# CITY OF PORTLAND BUILDING PERMIT

**PERMIT ID:** 2012-65609

562 CONGRESS ST

has permission to **Fit up existing office space on 4th & 5th floors.**

Scale: AS NOTED
Date: 4 December 2012
4TH FLOOR
STOREFRONT ELEVATIONS

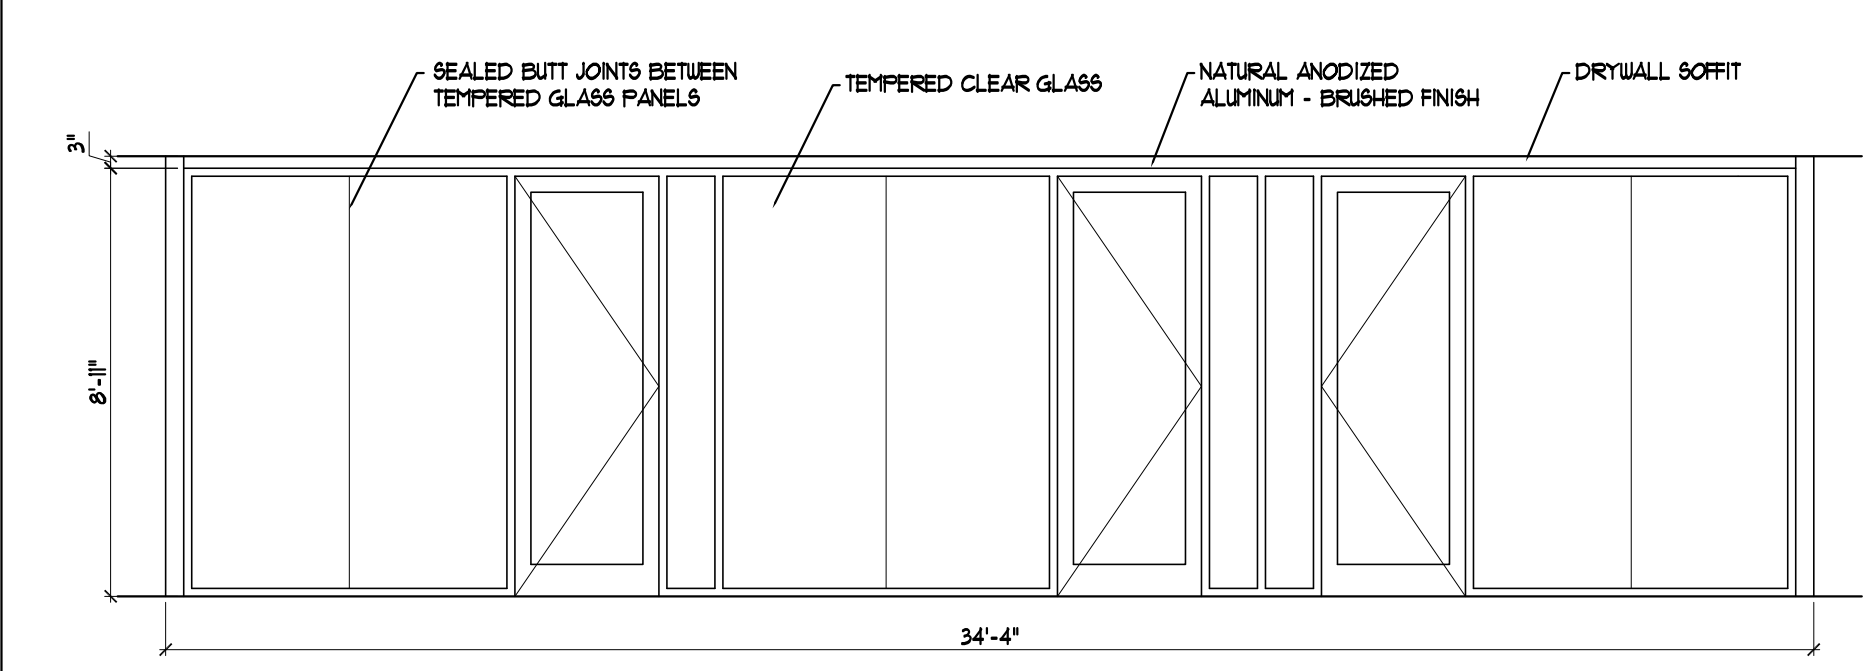
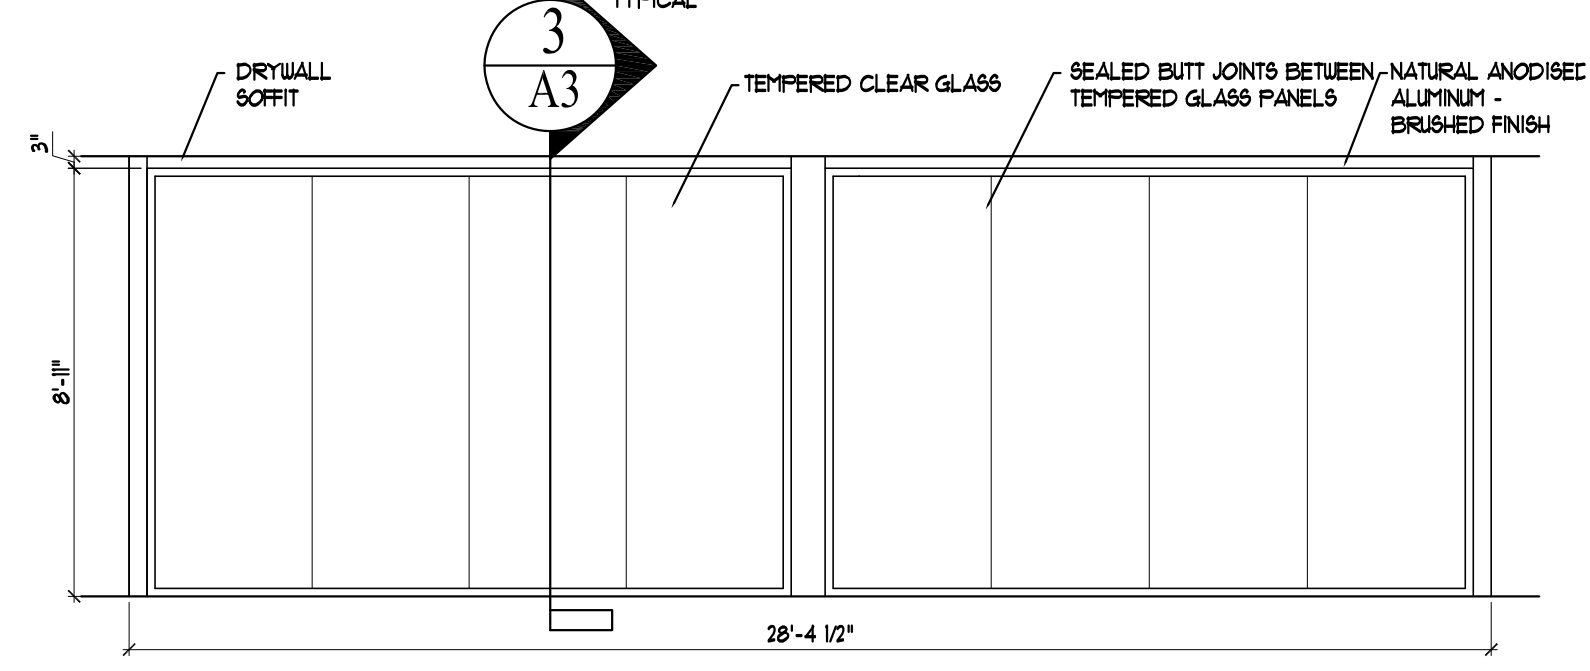
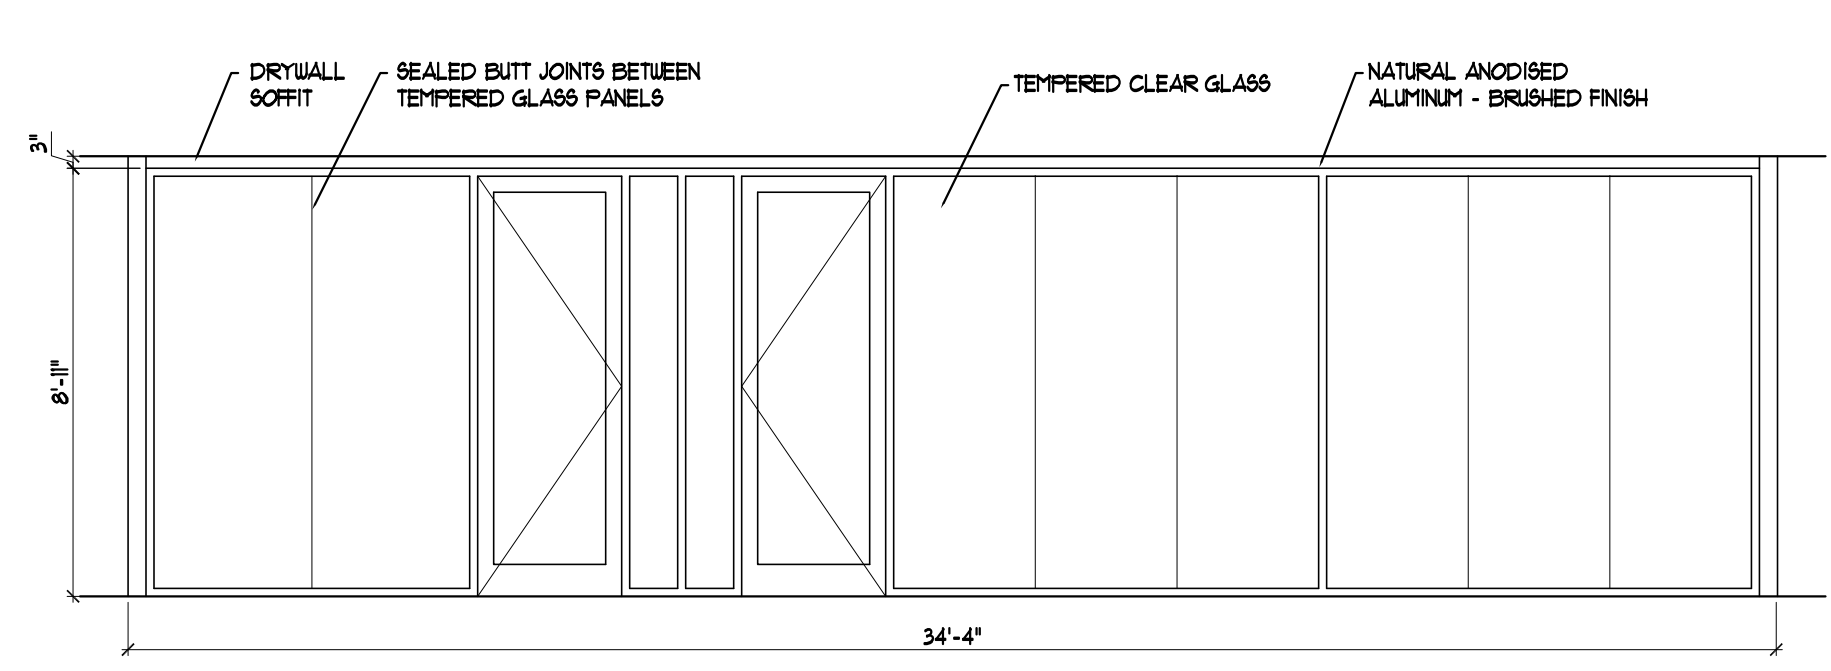
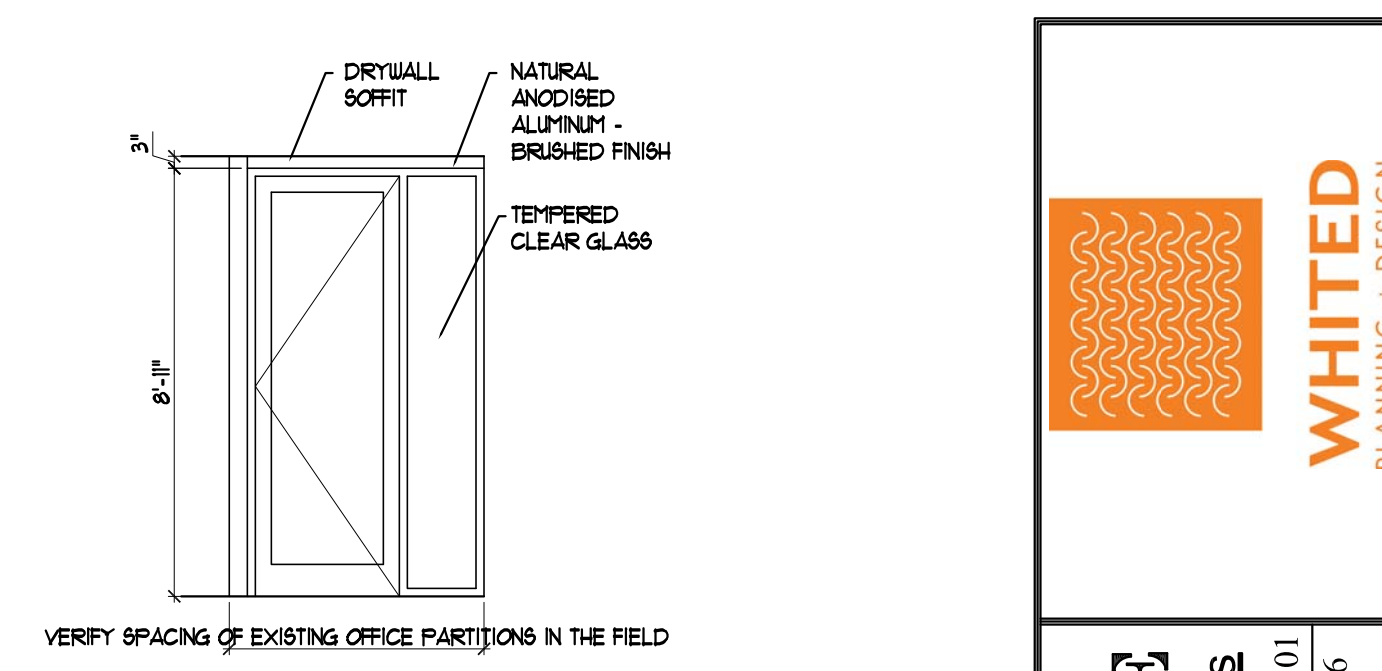
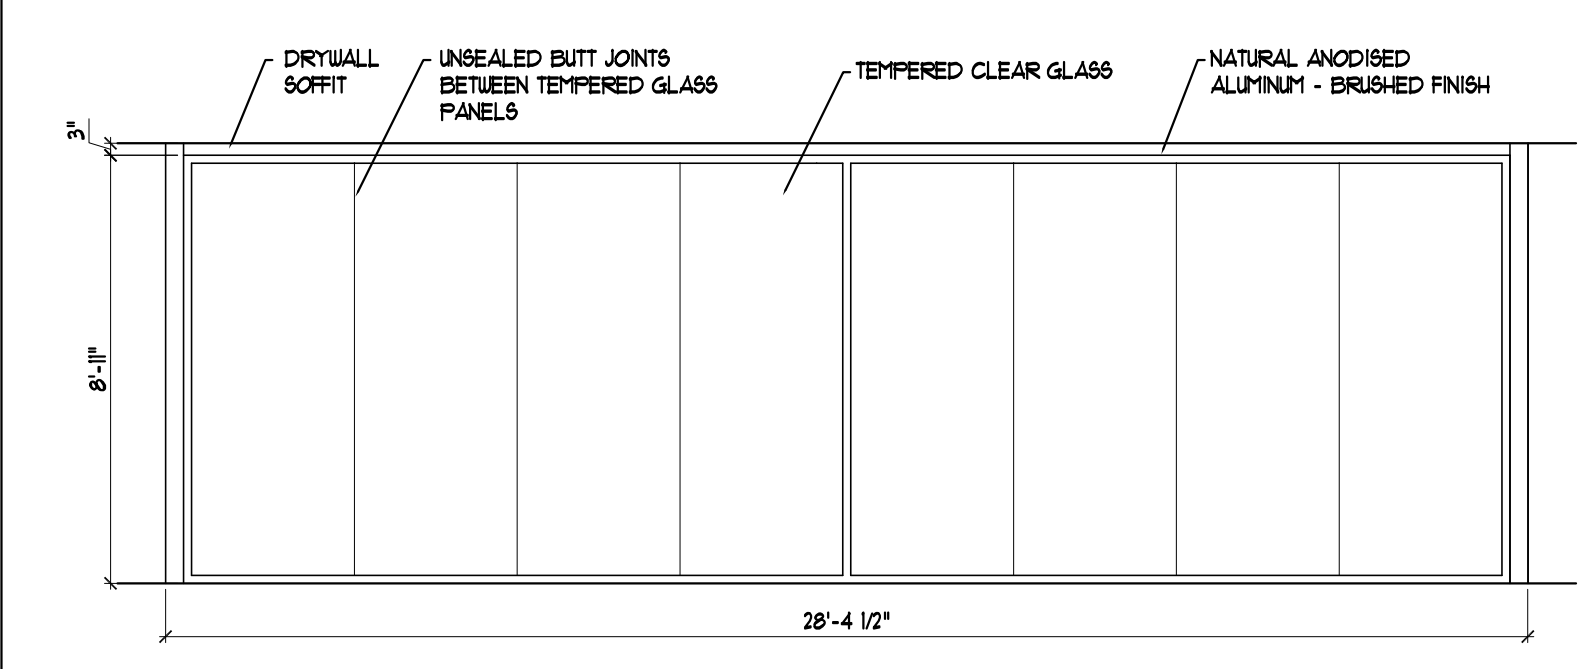
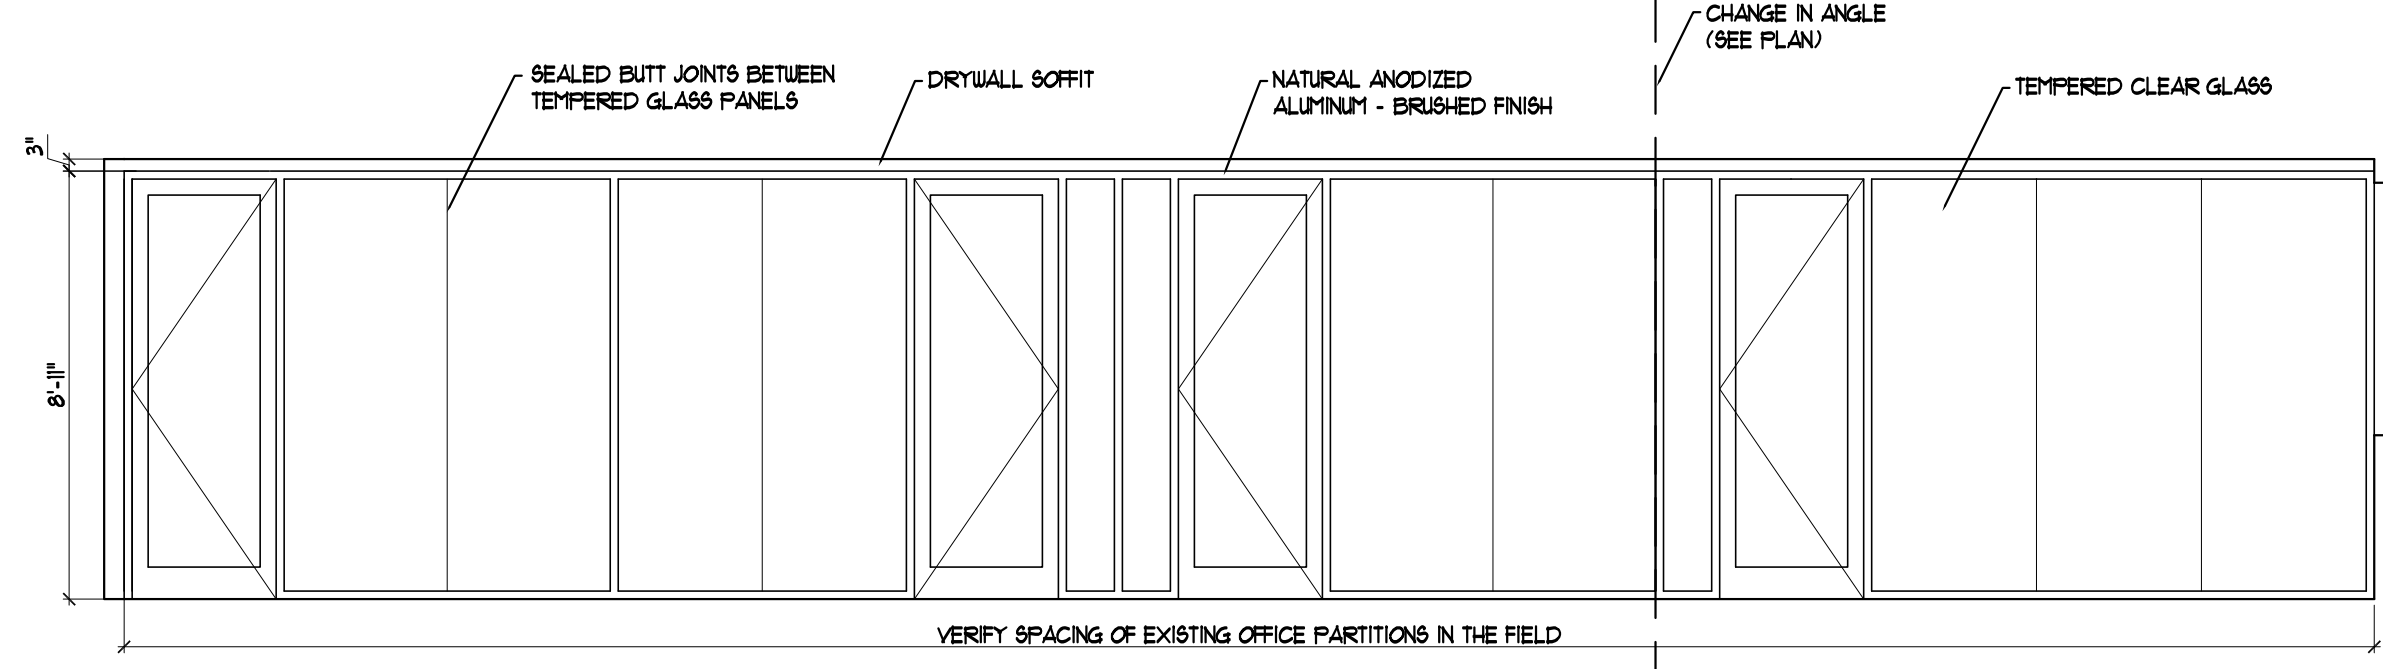
- 1) The glazed wall panels shall meet the loading requirements of IBC Sec. 2403 and Chap. 16.
- 2) Application approval based upon information provided by the applicant or design professional. Any deviation from approved plans requires separate review and approval prior to work.
- 3) Separate permits are required for any electrical, plumbing, sprinkler, fire alarm, HVAC systems, heating appliances, including pellet/wood stoves, commercial hood exhaust systems and fuel tanks. Separate plans may need to be submitted for approval as a part of this process.
- 4) Any modifications to existing building systems and all new systems (HVAC, electrical, plumbing) shall meet IECC 2009 or ASHRAE 90.1-2007 requirements for energy code compliance.
